# Rezoning Transportation Analysis

Petition Number: 2023-011

## Revision Log:

Date	Description
5-24-23	First Review (TM)
6-21-23	Second Review (DR)
7-28-23	Third Review (ME)

C1.01

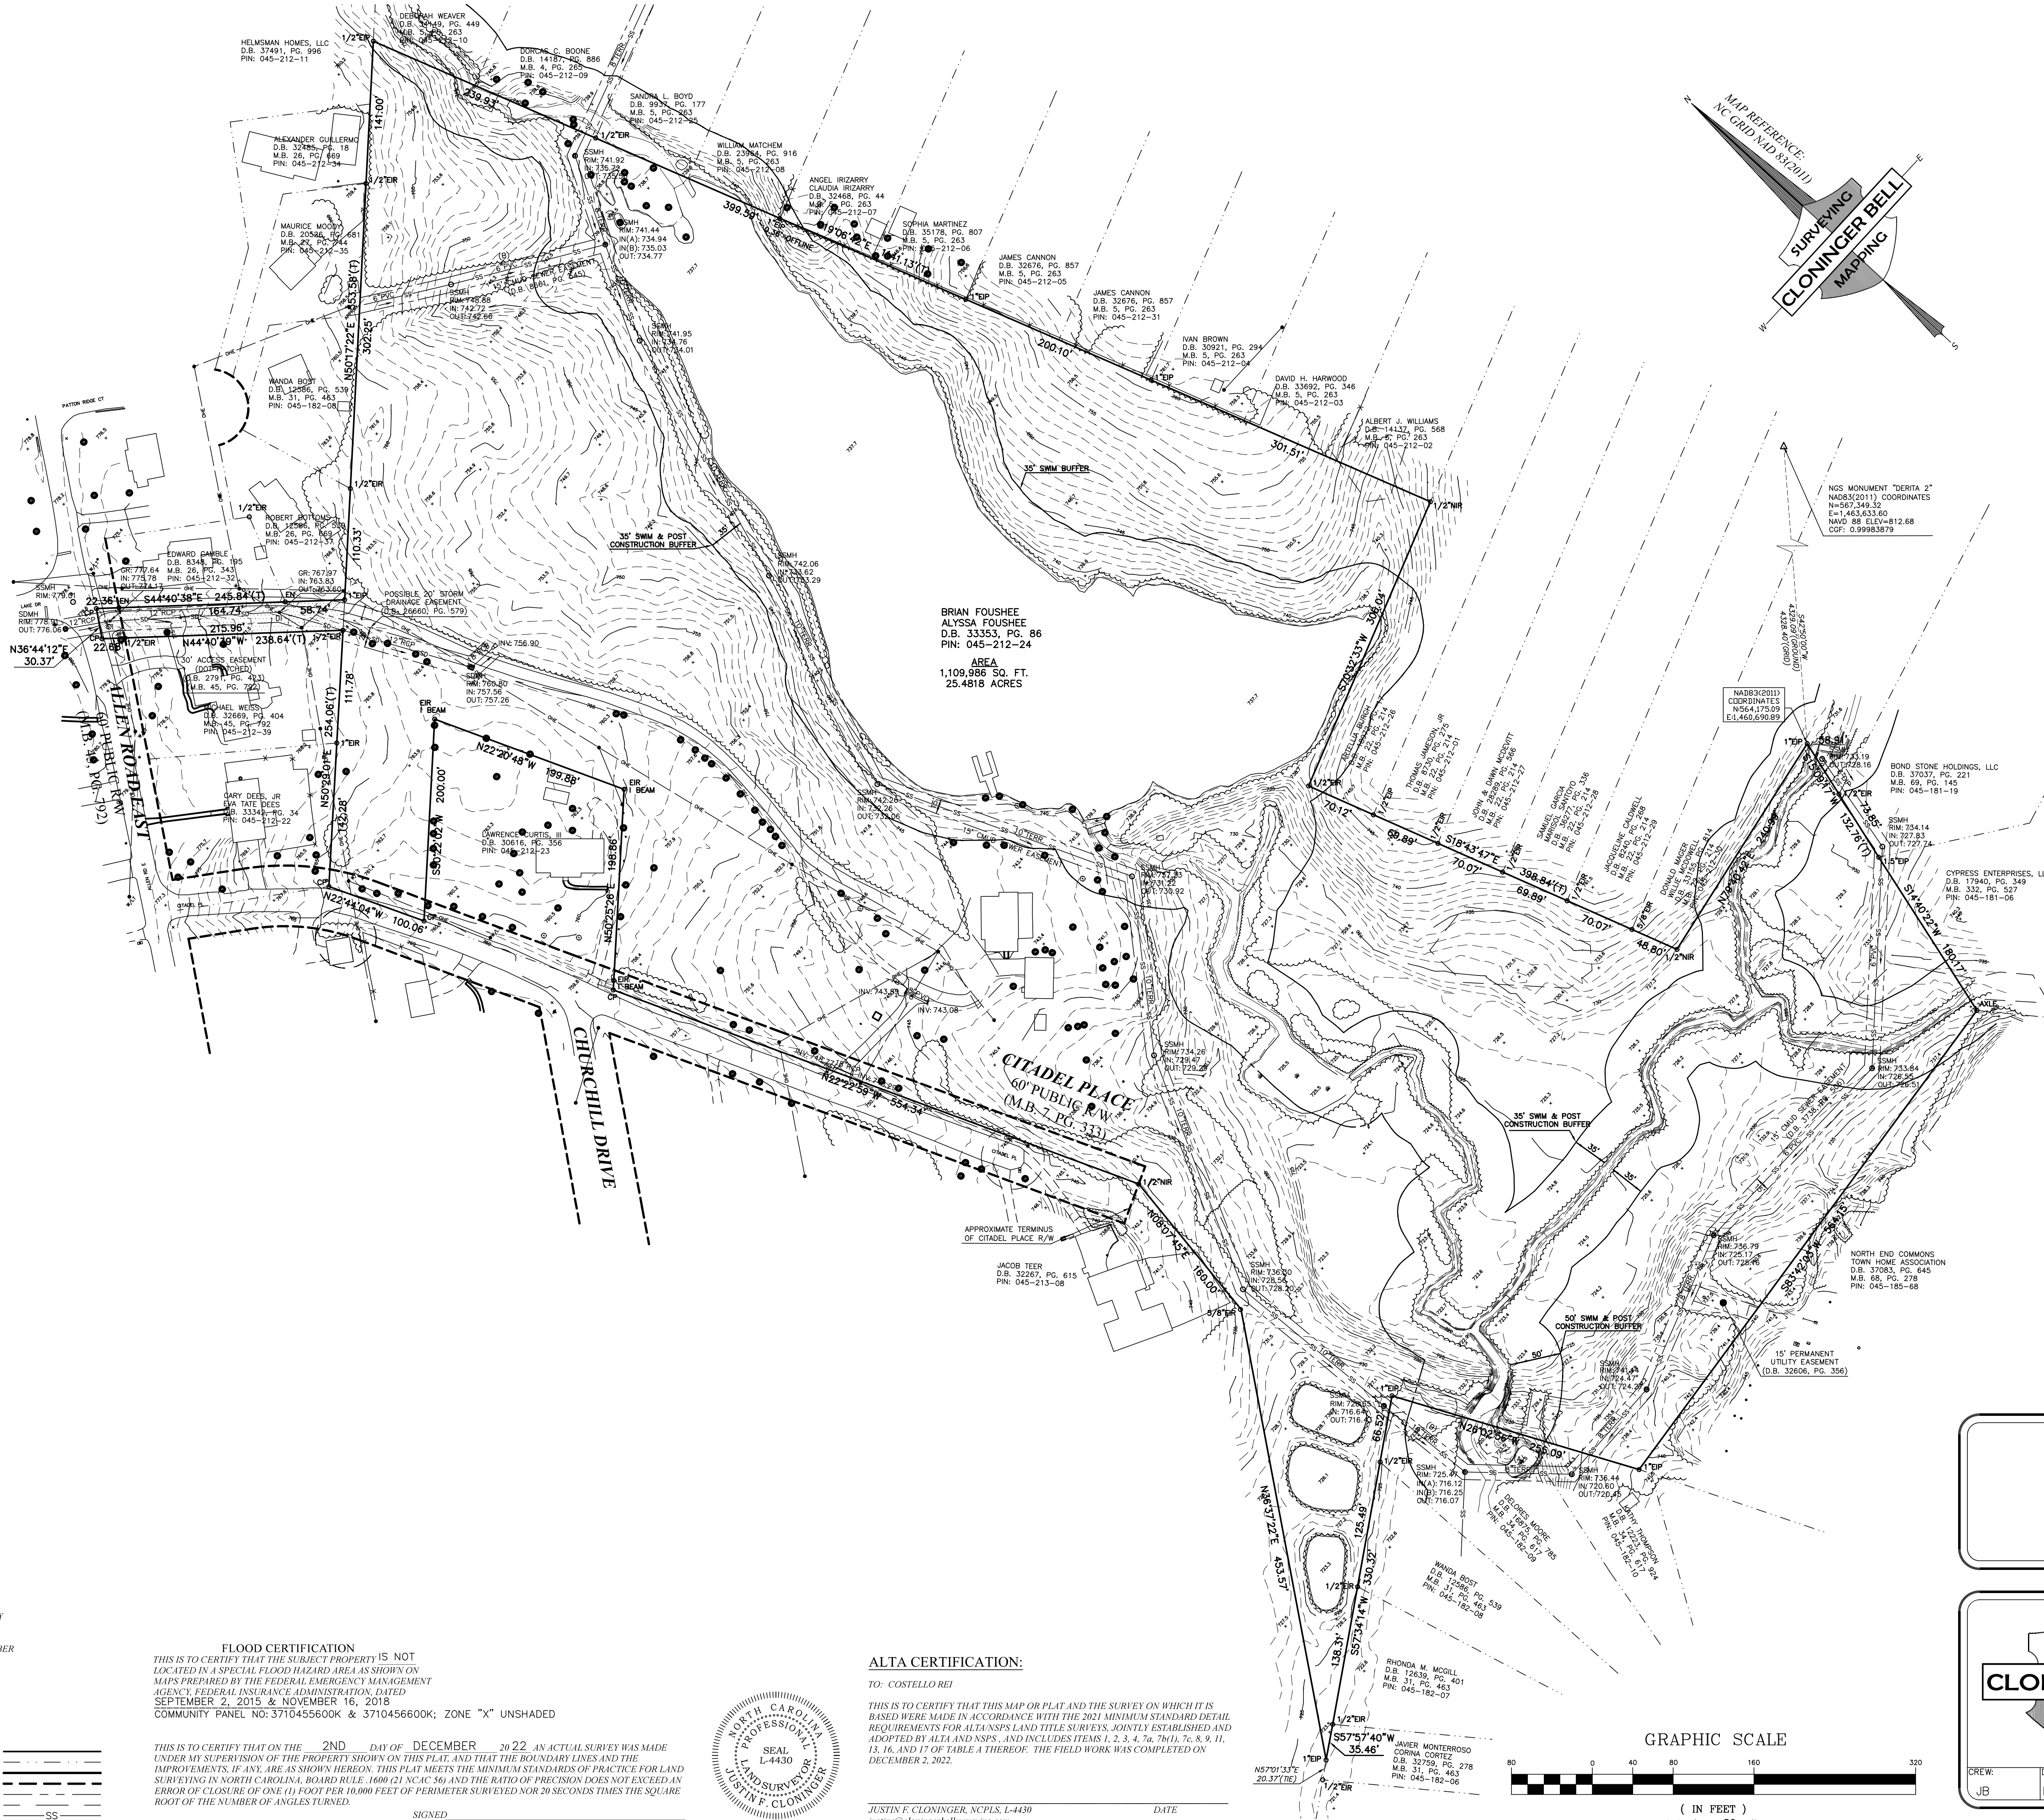
- a. ~~**Citadel Place:** Location of curb and gutter to be moved to 13 feet from roadway centerline to accommodate the Charlotte Streets Map with a roadway typical section of Local Residential medium.~~

~~Label and dimension the curb and gutter from the centerline for each road on the site plan.~~

**3. ~~Revise site plan and conditional note(s) to commit to dedicate 30 feet of right-of-way from the road centerline. The site plan shall label and dimension the right-of-way from the road centerline.~~**

**Clarifying comment 6.21.2023:** ~~Add conditional note to commit to dedicate 30 feet of ROW from the road centerline of Citadel Place. Additionally label and dimension.~~

**4. ~~Revise site plan and conditional note(s) to commit to construct an 8-foot planting strip, and 6-foot sidewalk on all internal roadways Chapter 19. The site plan shall label and dimension both items from the back of curb and gutter or edge of pavement.~~**

**Clarifying comment 6.21.2023:** ~~Add conditional note to construct 8-foot planting strip and 6-foot sidewalk on all internal roadways.~~

6. ~~Revise site plan and conditional note(s) to commit to streetscape along both sides of all proposed roadways.~~

7. ~~Revise site plan and conditional note(s) to commit to revising the proposed hammerhead to a cul de sac as to not stub to the single family homes to the North of the petition.~~
